From: Charlotte Watkins
Sent: 12 March 2020 21:26
To: Caroline Ford
Subject: RE: 19/02958/F - Foul water tank and pumping station etc - Holiday Inn Express, Bicester

From: Caroline Ford <Caroline.Ford@Cherwell-DC.gov.uk>
Sent: 10 March 2020 11:19
To: Iain Osenton <iain.osenton@cherwell-dc.gov.uk>; Charlotte Watkins <Charlotte.Watkins@Cherwell-DC.gov.uk>
Subject: FW: 19/02958/F - Foul water tank and pumping station etc - Holiday Inn Express, Bicester

Further to your comments made in terms of the above planning application (which proposed a removal of a hedgerow, storage and then its reinstatement), the applicant has now provided a response in the attached. They now advise that it is not necessary for the hedgerow to be temporarily removed and so propose a method statement regarding working within proximity to the hedgerow.

Drawn By: EG Approved By: IM Date: 01.03.19 Scale: 1:200 @ A0  
 Drawing Number: M19002/E/600  
 Revision: F

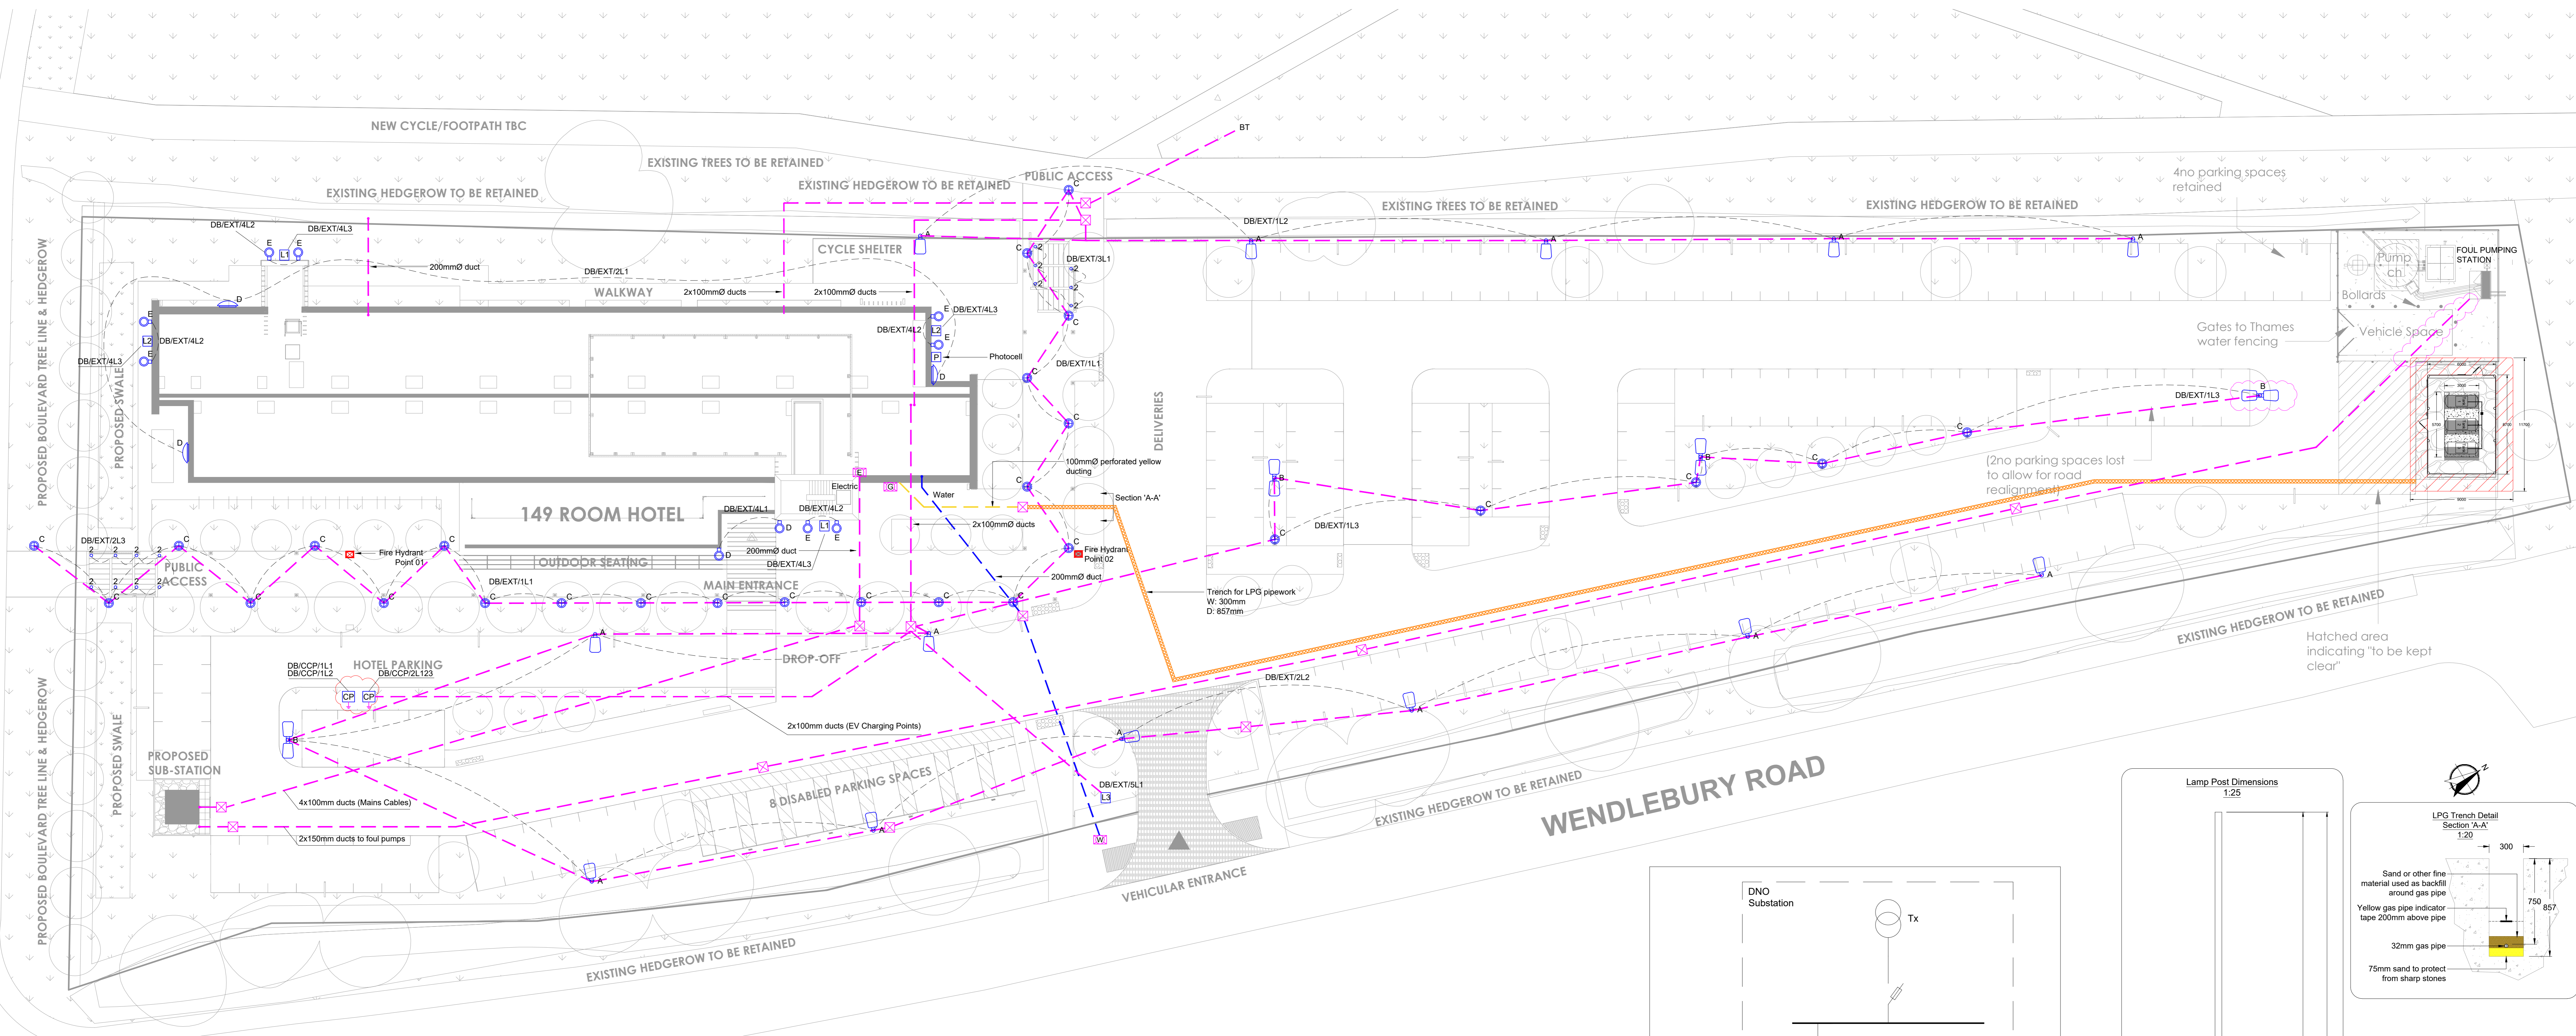
She has also raised a concern regarding the 6m lighting columns to the west of the site which are within or adjacent to the 'existing hedgerow to be retained' as these are likely to unavoidably cause an unacceptable amount of light spill into the hedgerow if sited in that location. Their relocation further into the car park and their number reduced would be beneficial.
